From: Gareth Lewis [REDACTED]
Sent: 24 September 2020 19:40
To: Planning <Planning@arun.gov.uk>
Subject: Application reference M/59/20/HH

We are writing in respect of the above application. Our address is 43 Southdean Drive which is directly opposite the site in question.

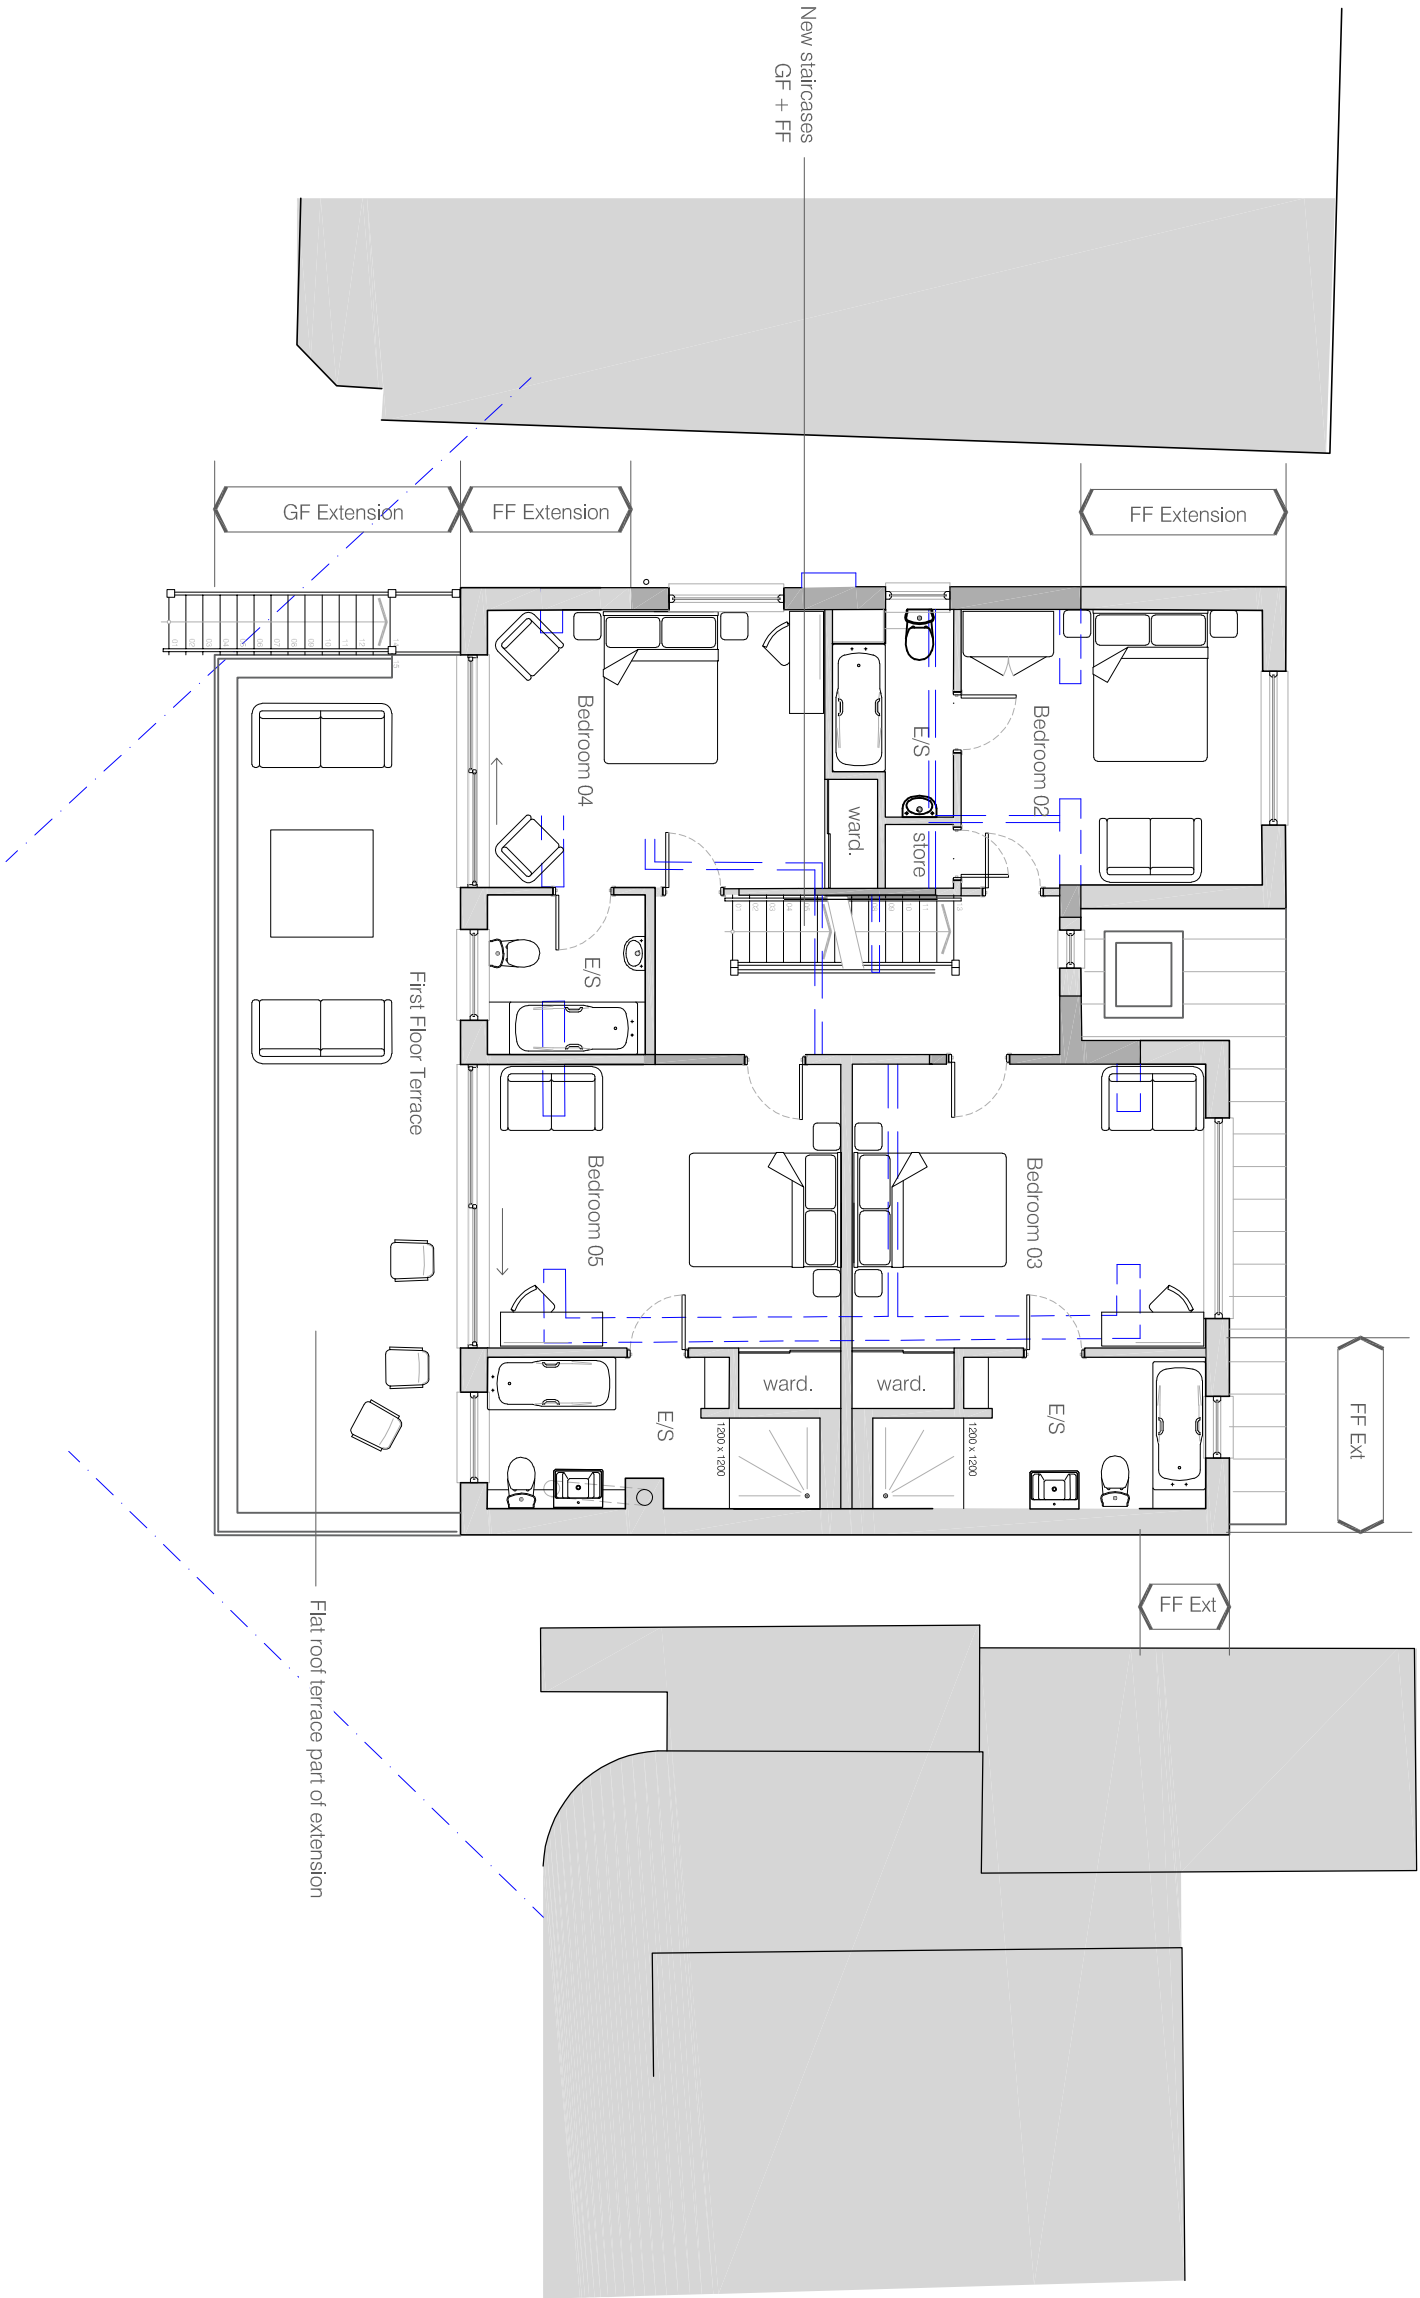
The increased height and width of the first floor and the width and height of the new second floor are very dominant on the overall plot.

CLIENT **Mark & Mellissa Muscat**
PROJECT **56 Southdean Drive**
DRAWING TITLE **Proposed Second Floor**

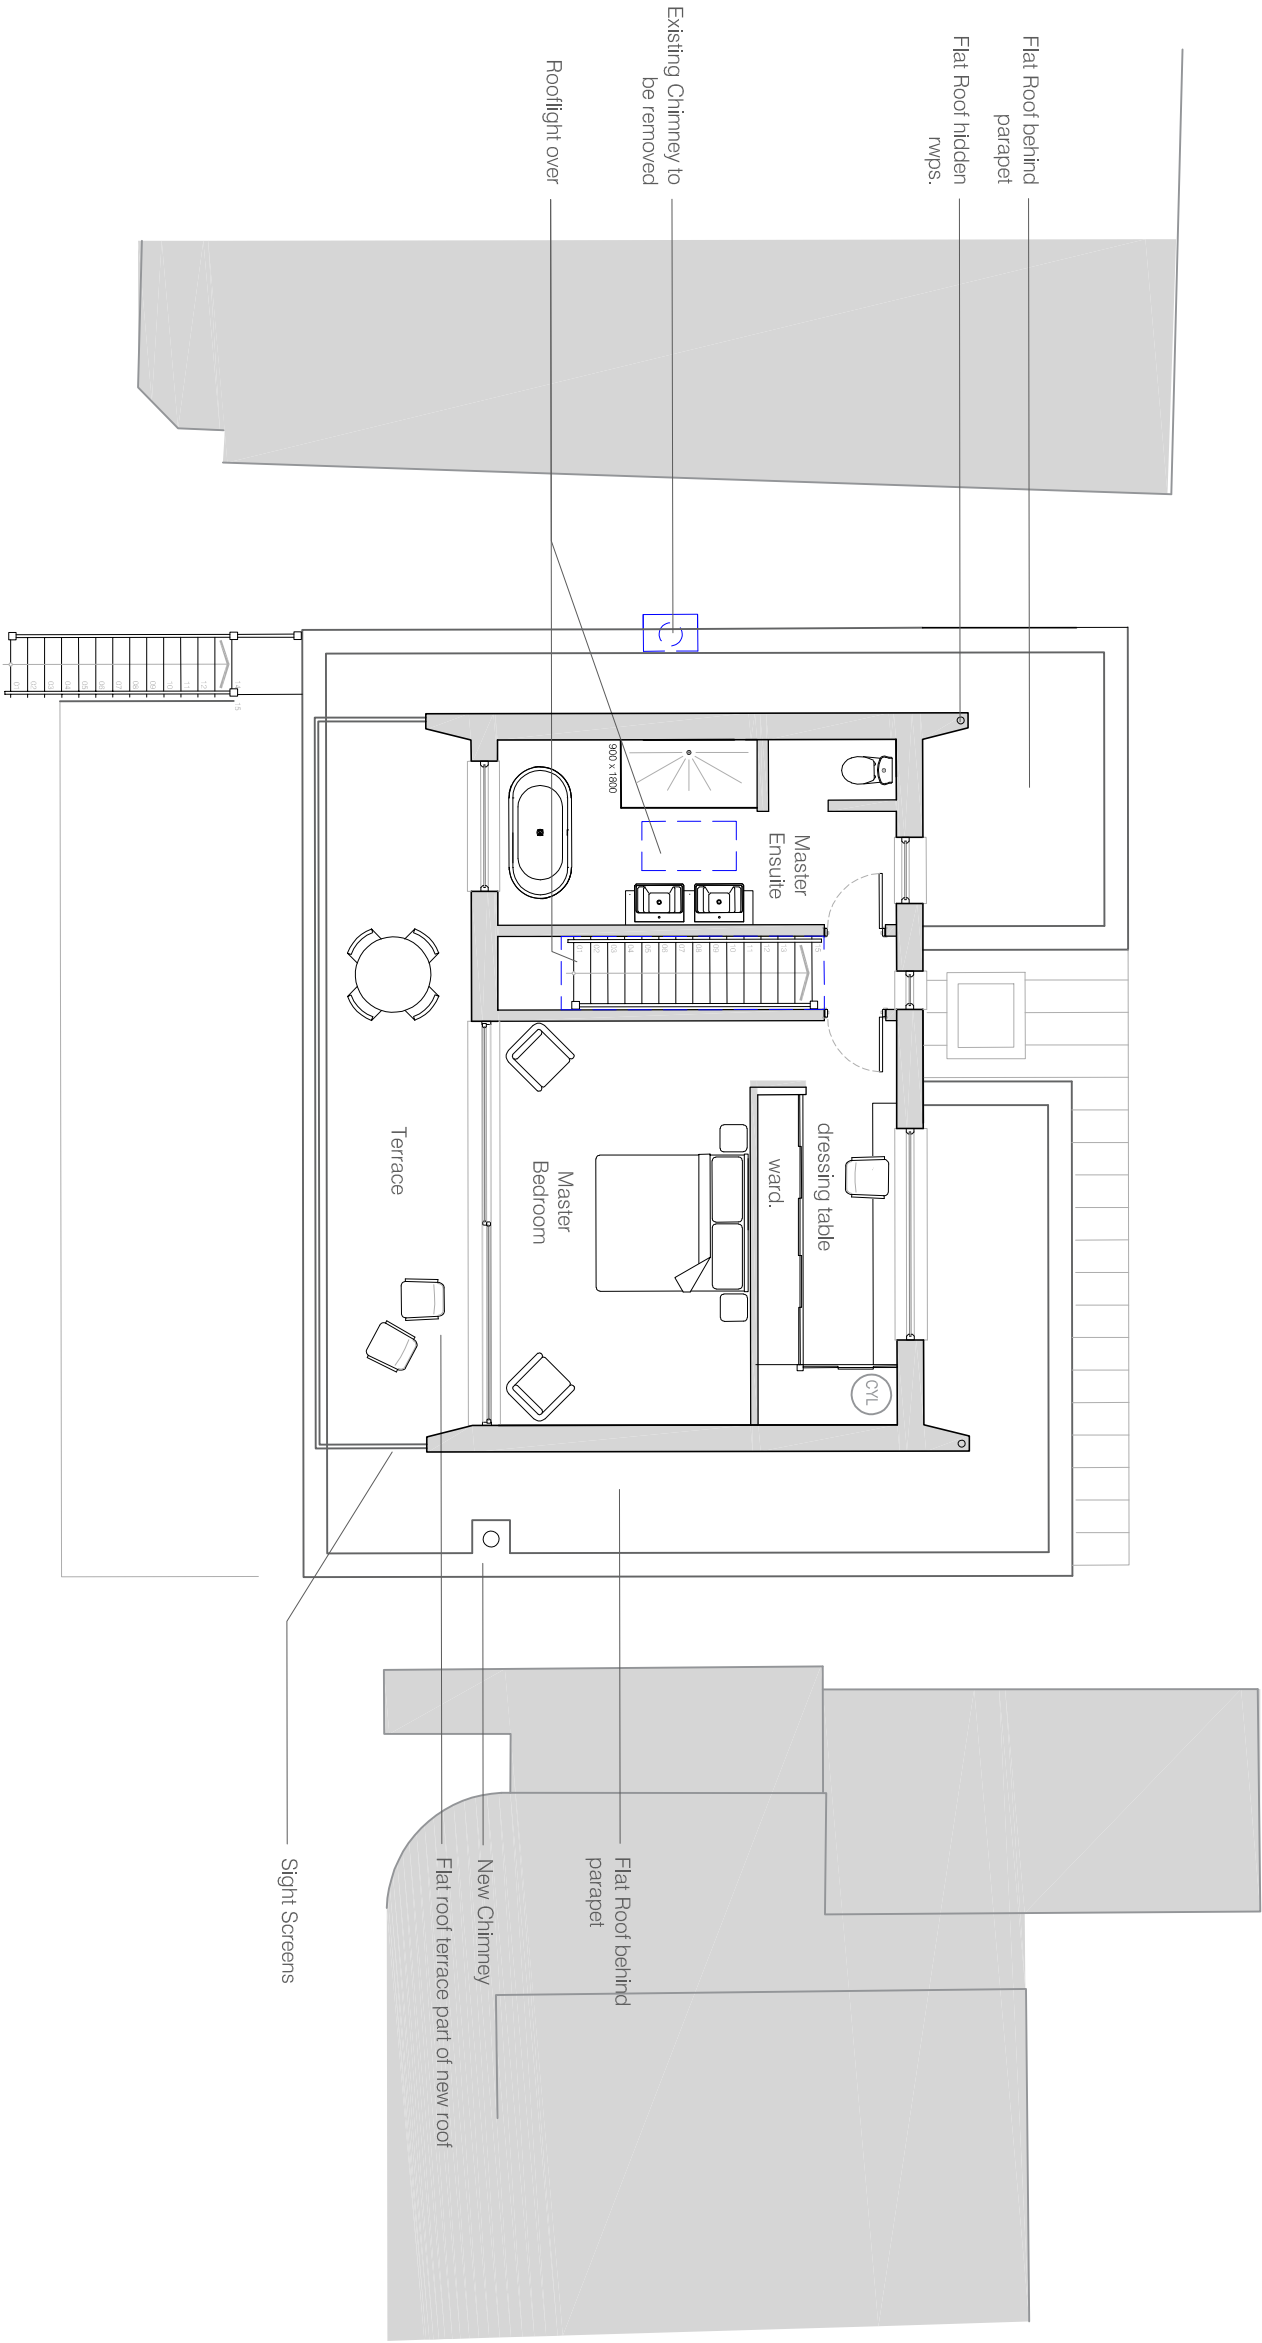
There are no other three storey properties utilising such an extensive width of the plot for the second floor portion.

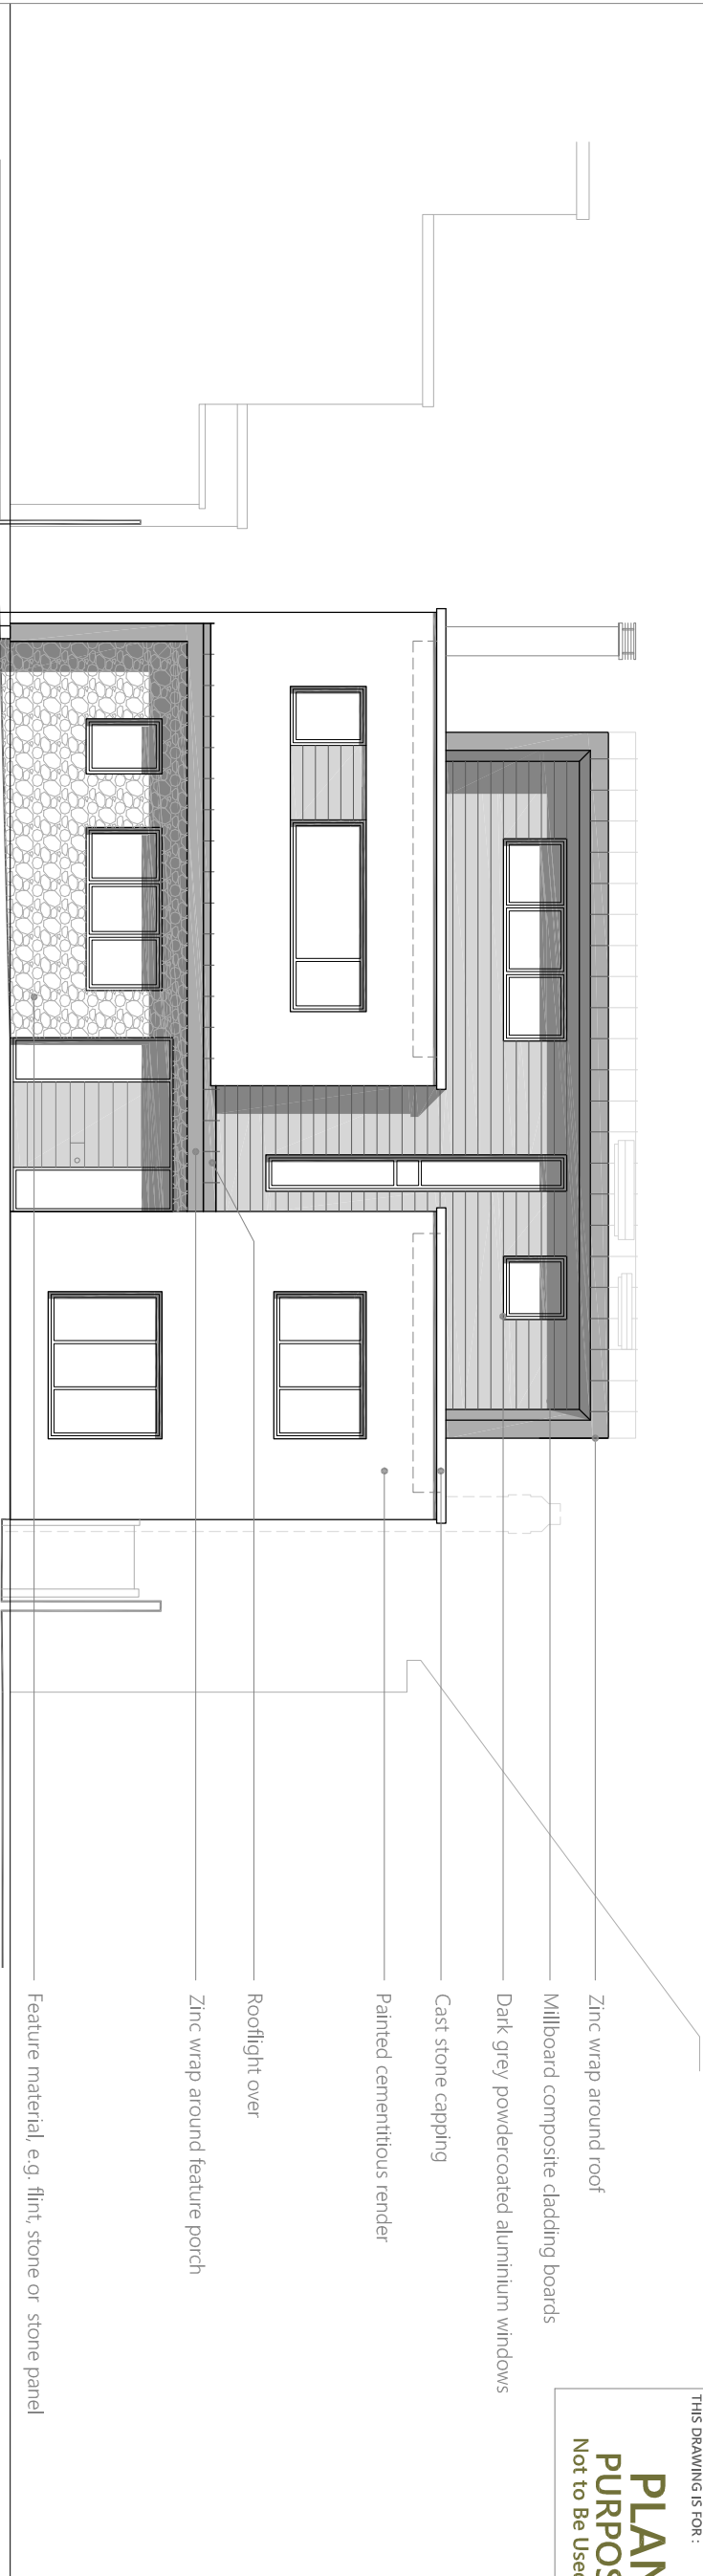
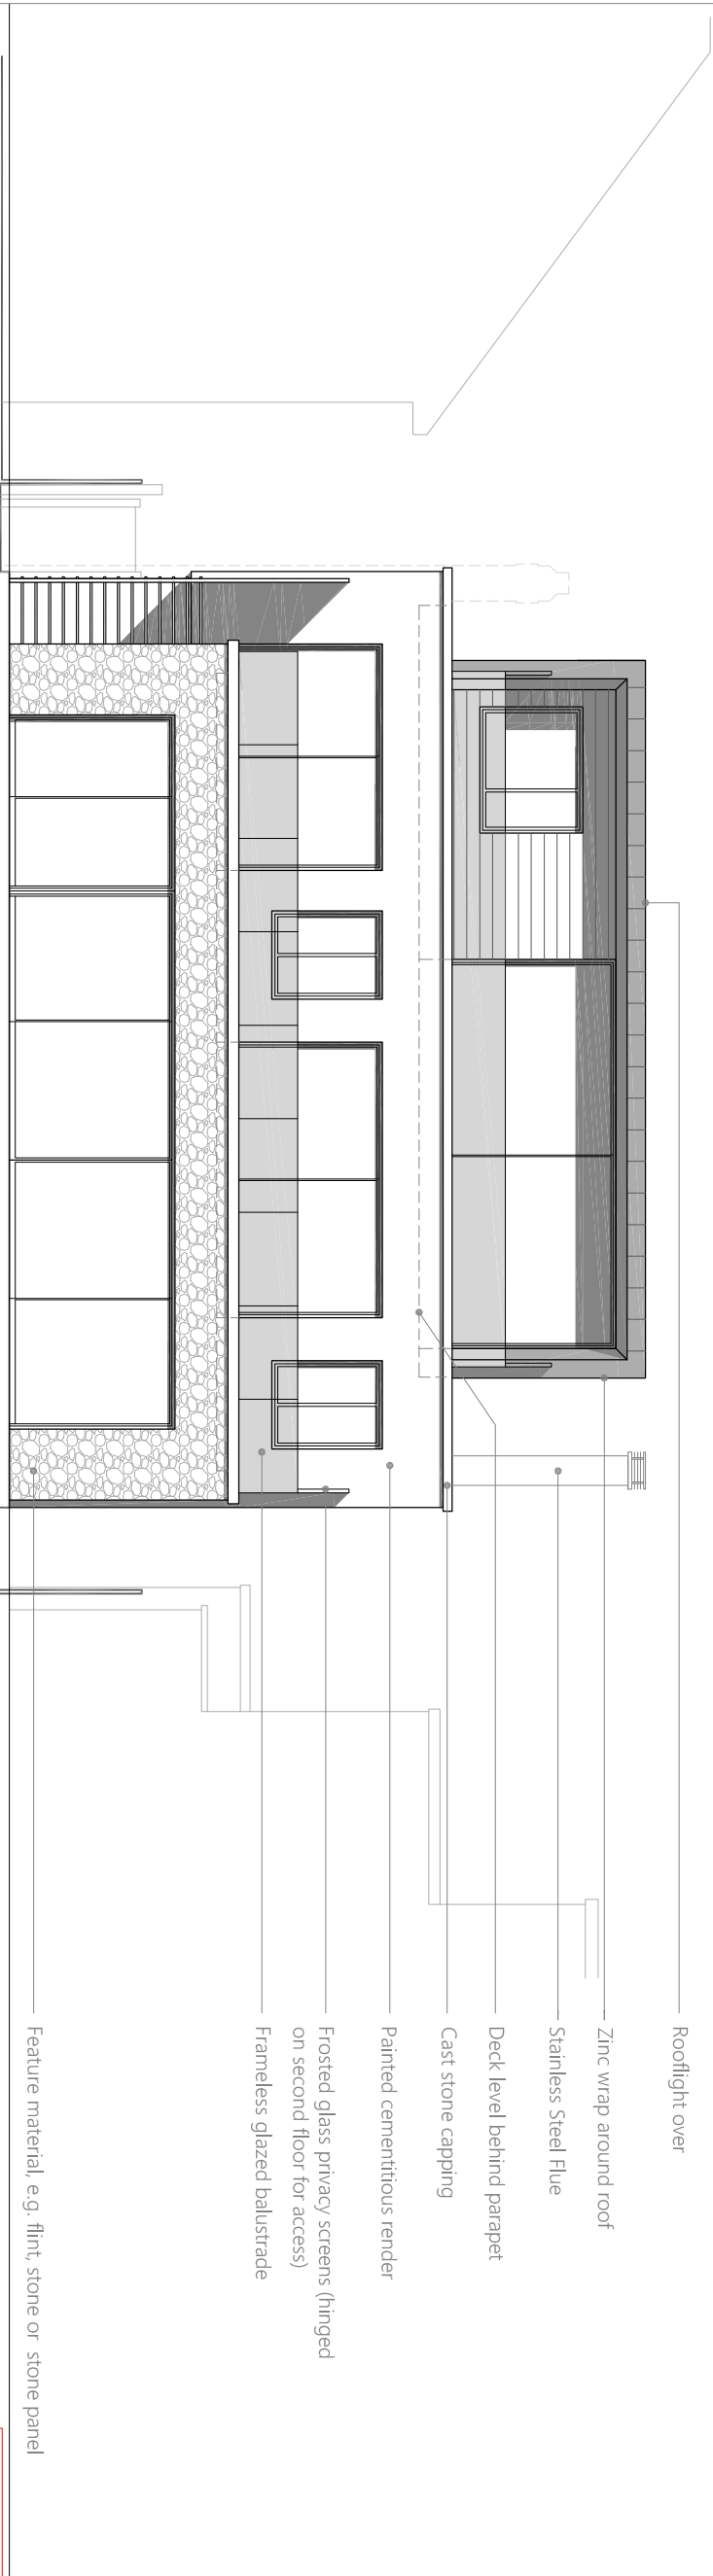
The extensive use of Zinc, dark grey window surrounds, stainless steel flue and - it appears - dark cladding boards give an industrial appearance to the overall building.
